MEMORANDUM

SUBJECT: SF-19-018 – Branding Iron at Sterling Ranch Filing No. 2
Response to Comments Letter

LANDSCAPE PLAN

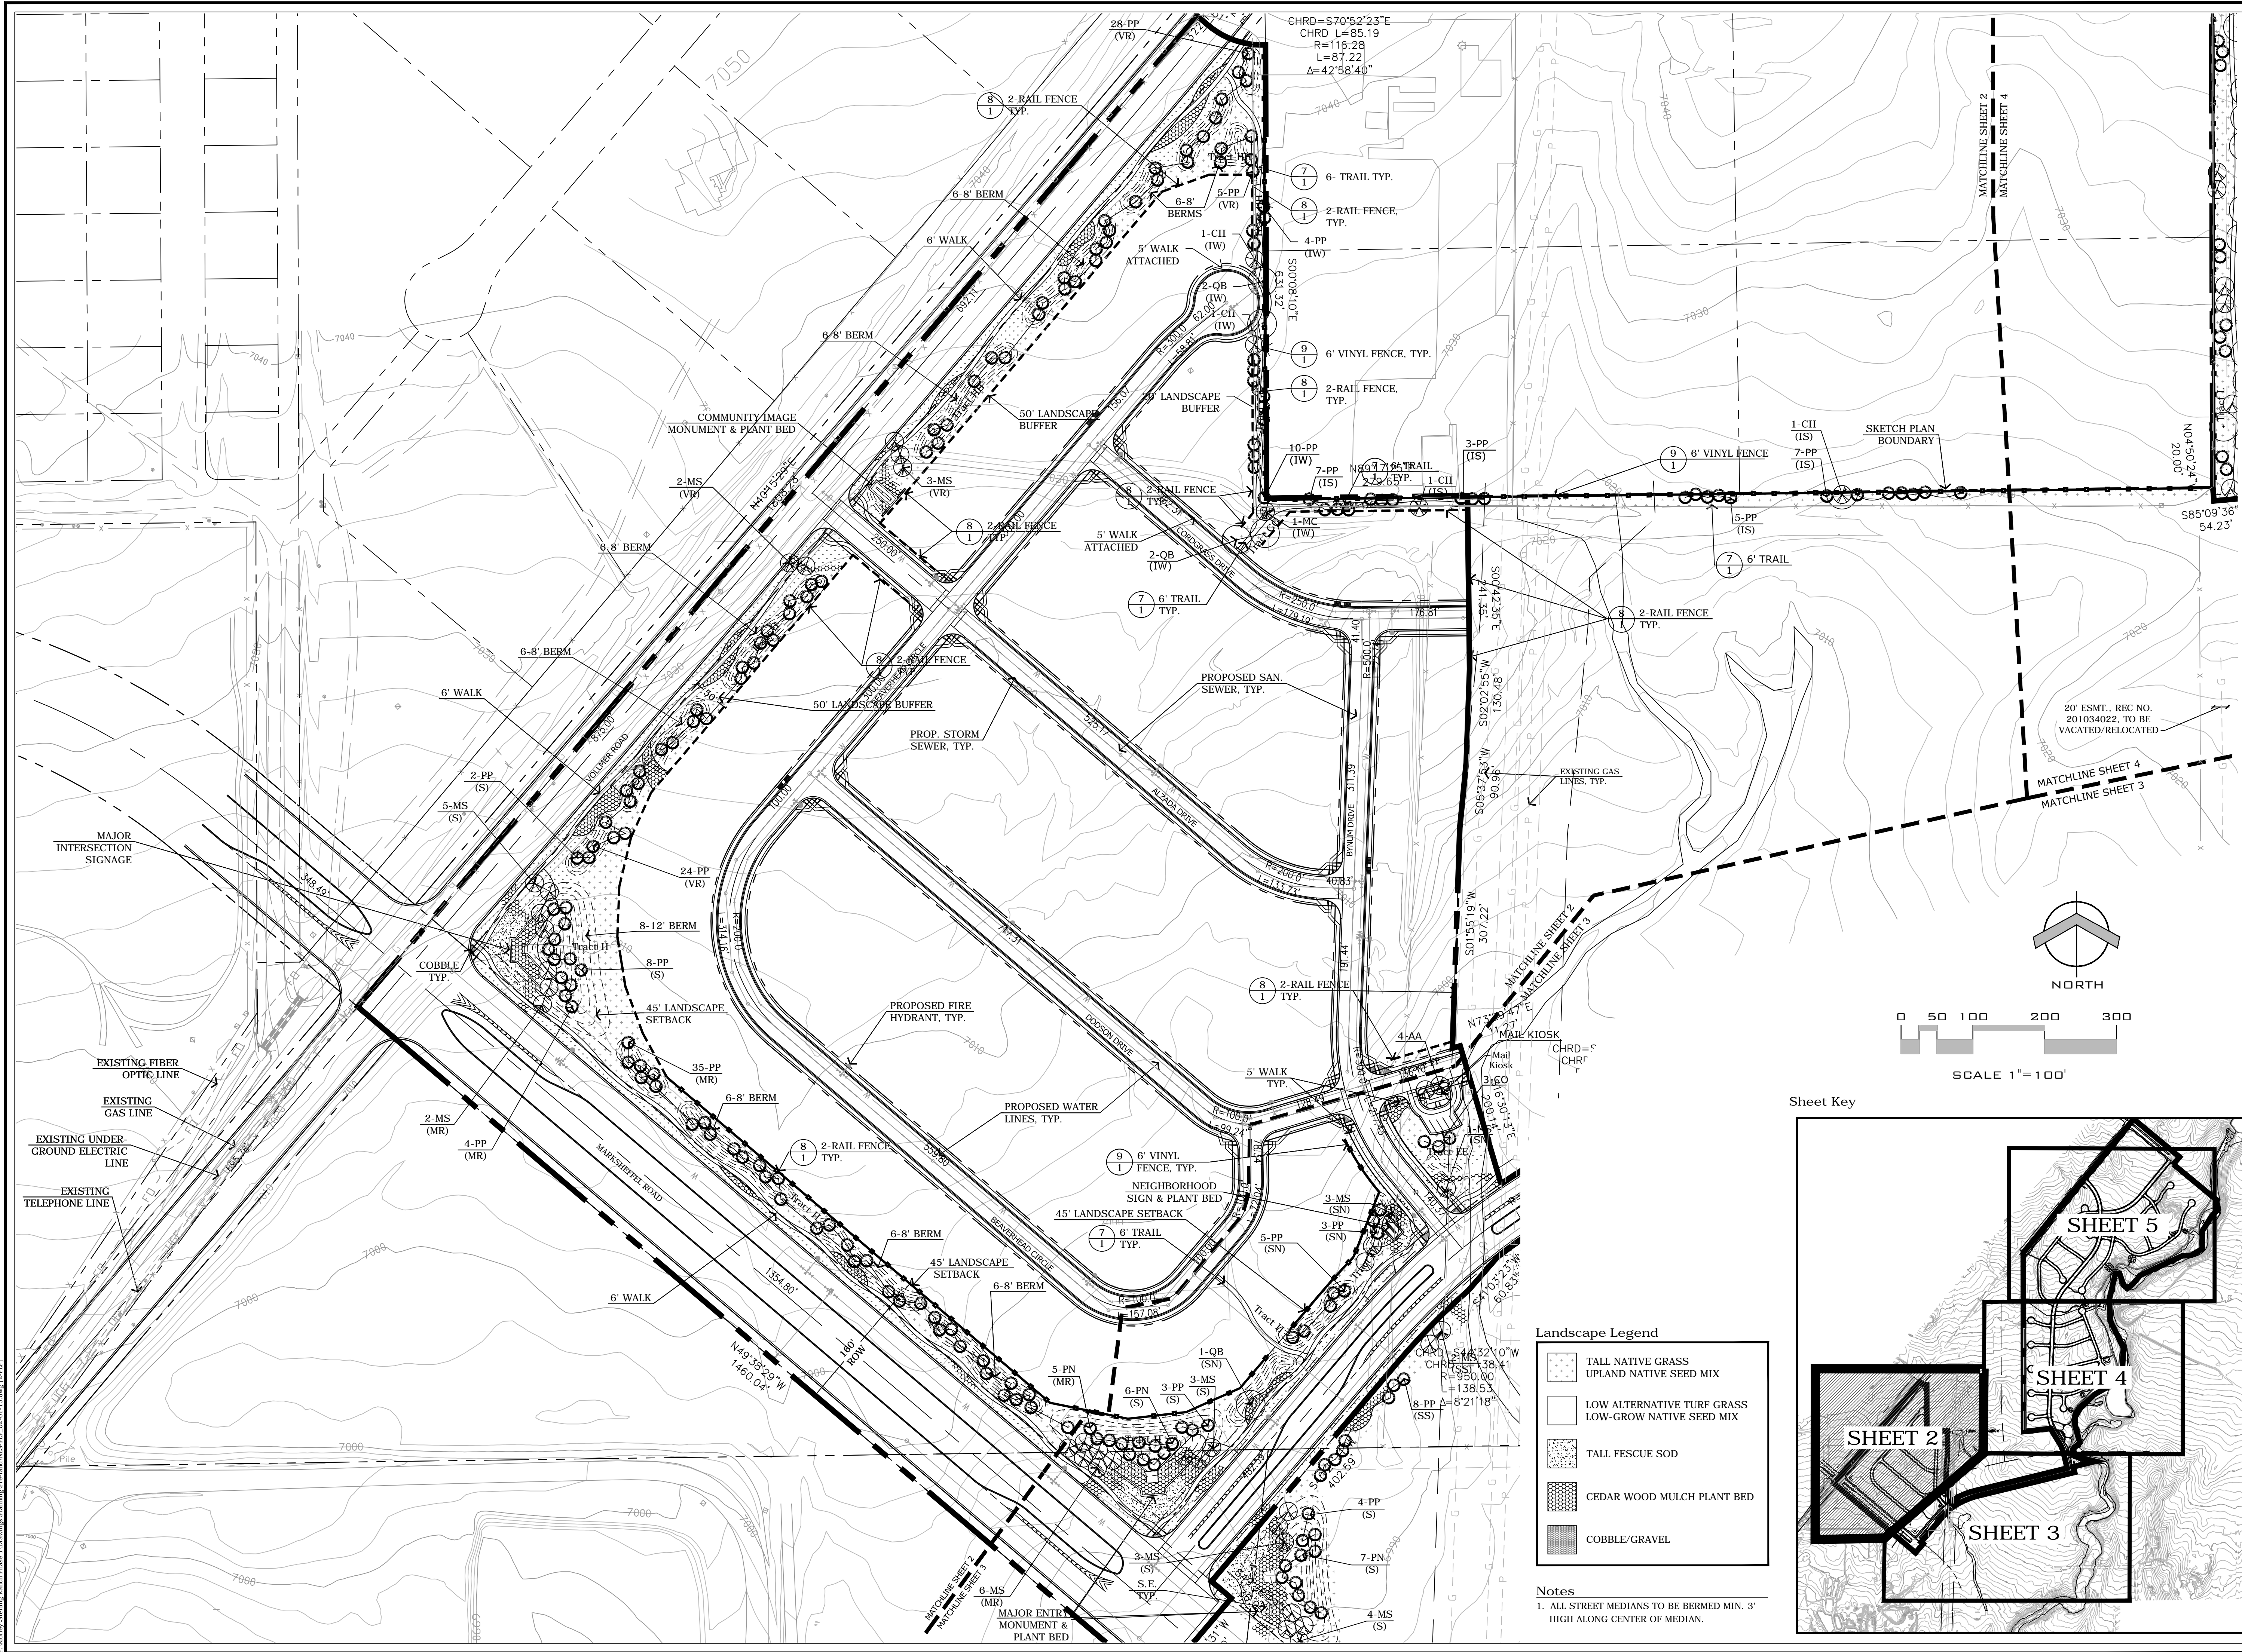
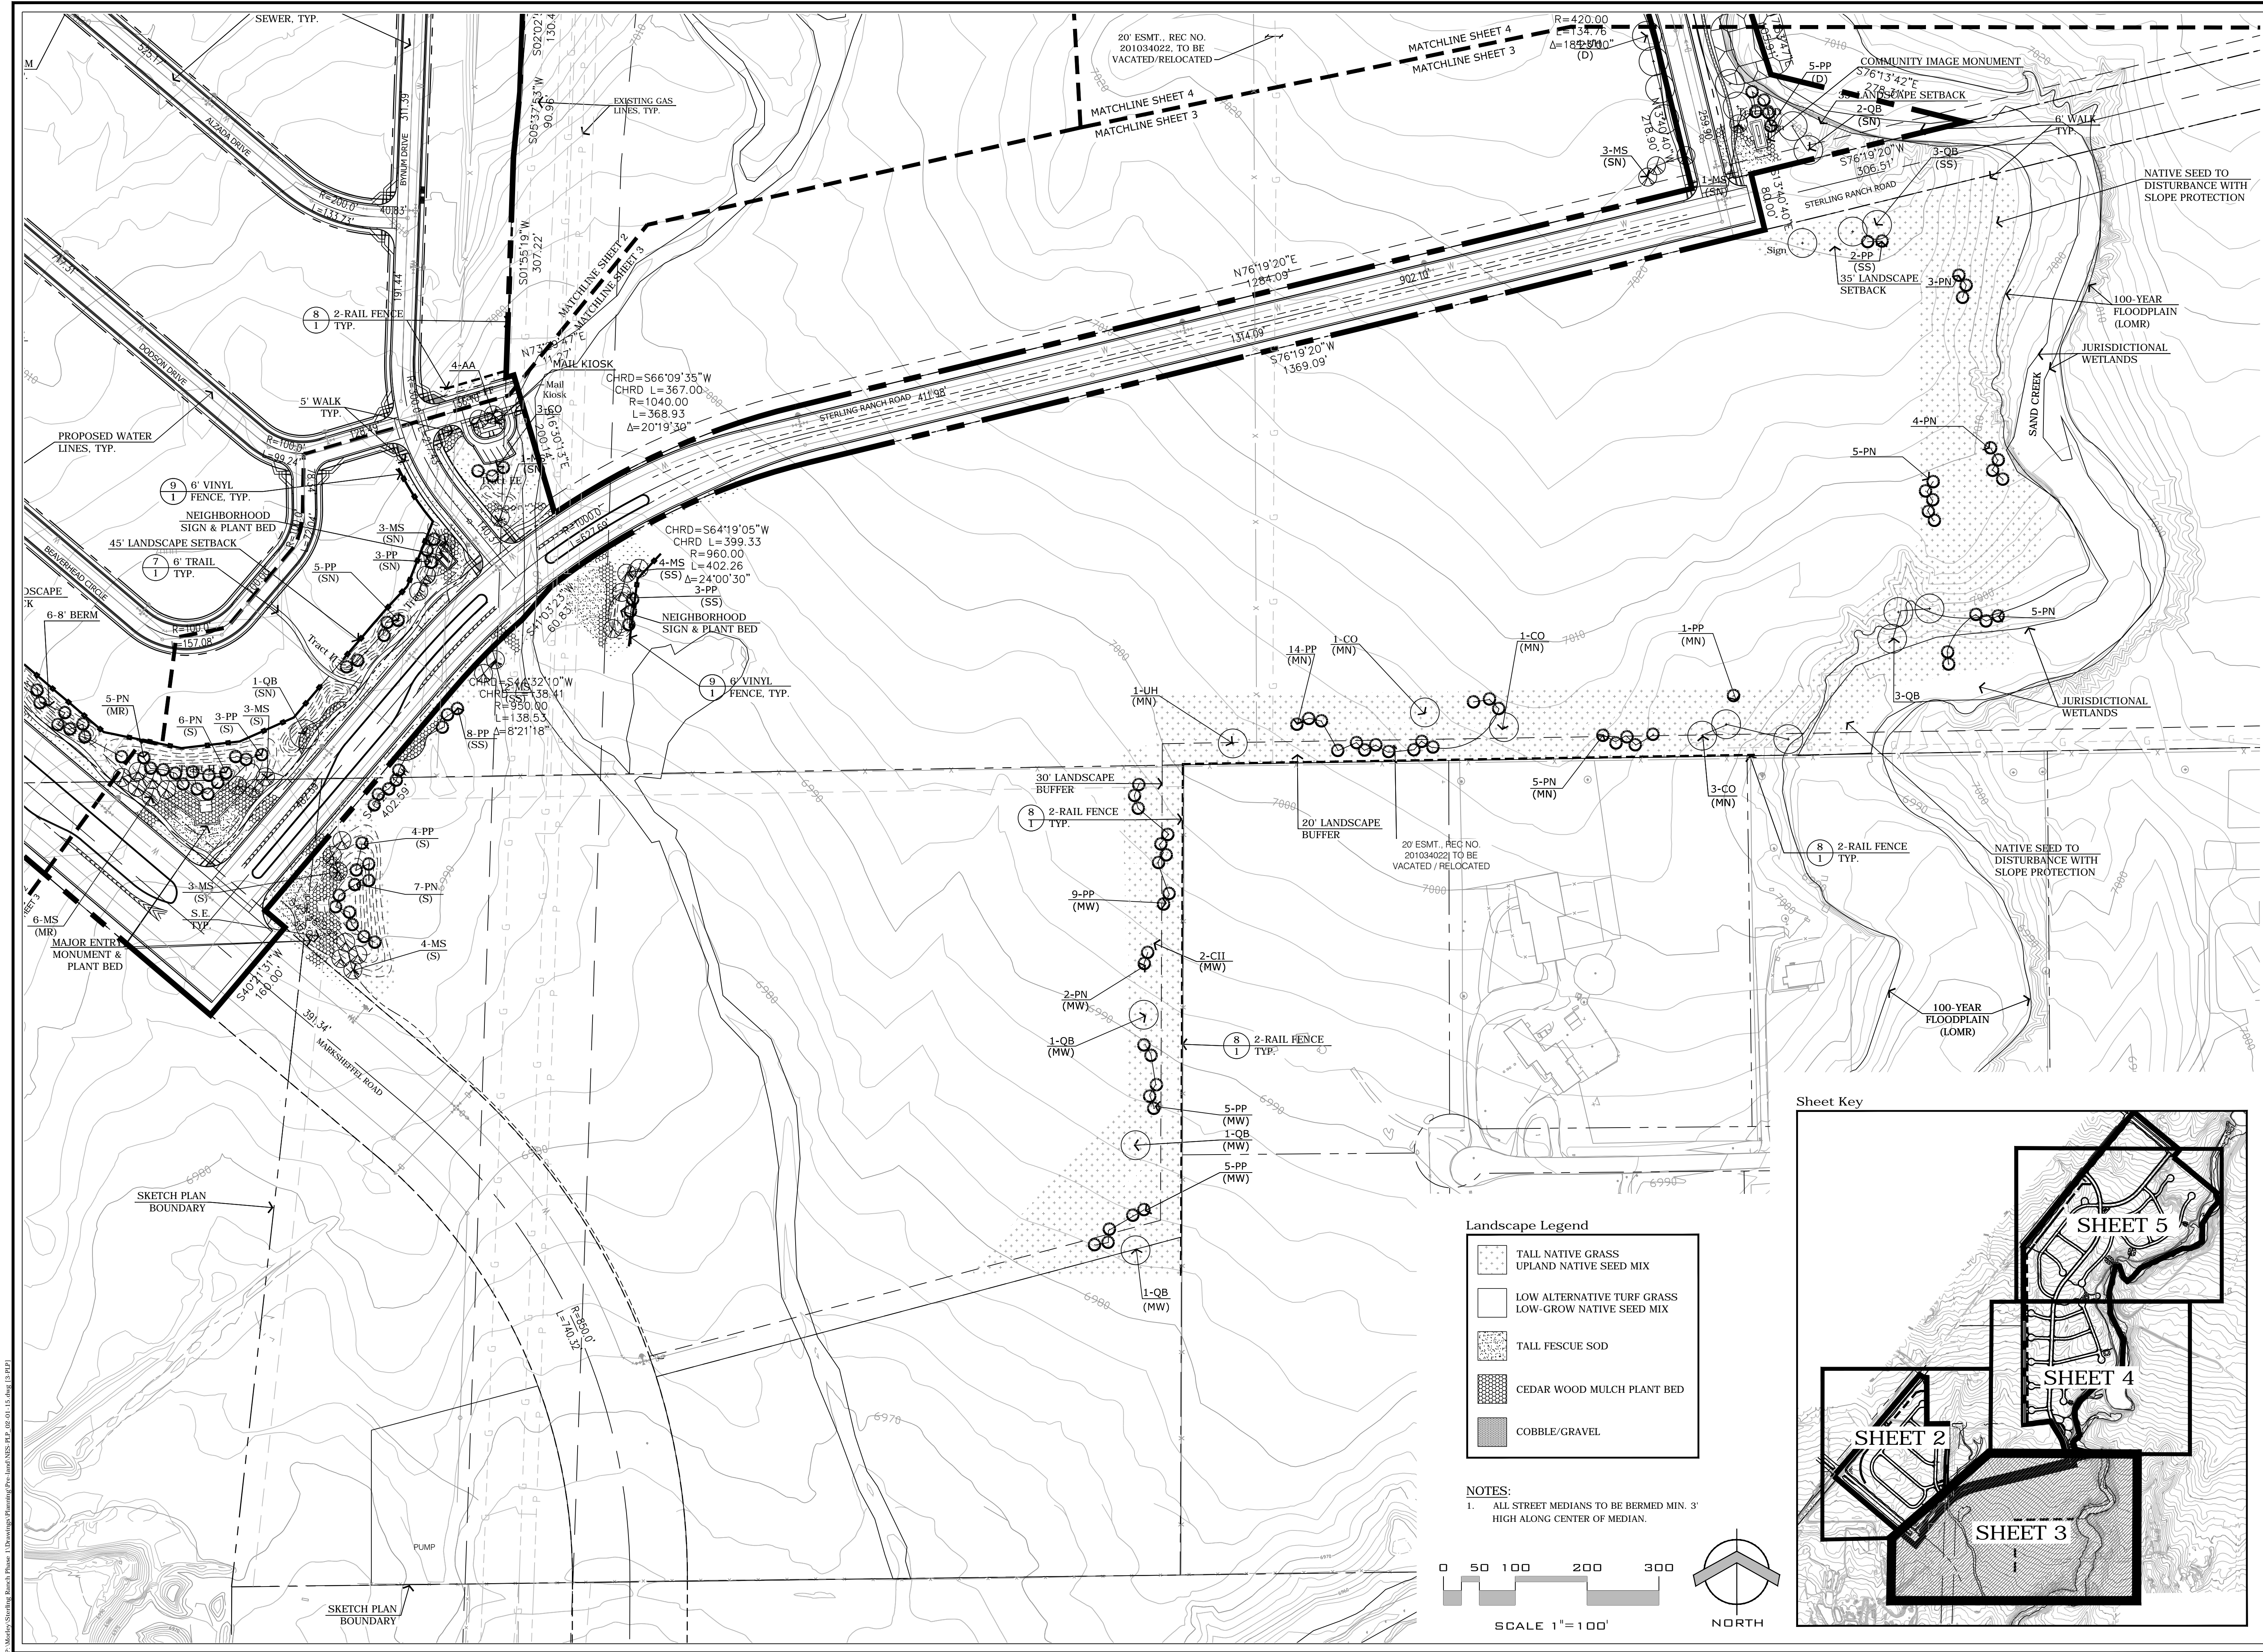
8. The landscape plan submitted is illegible. **Unresolved.**
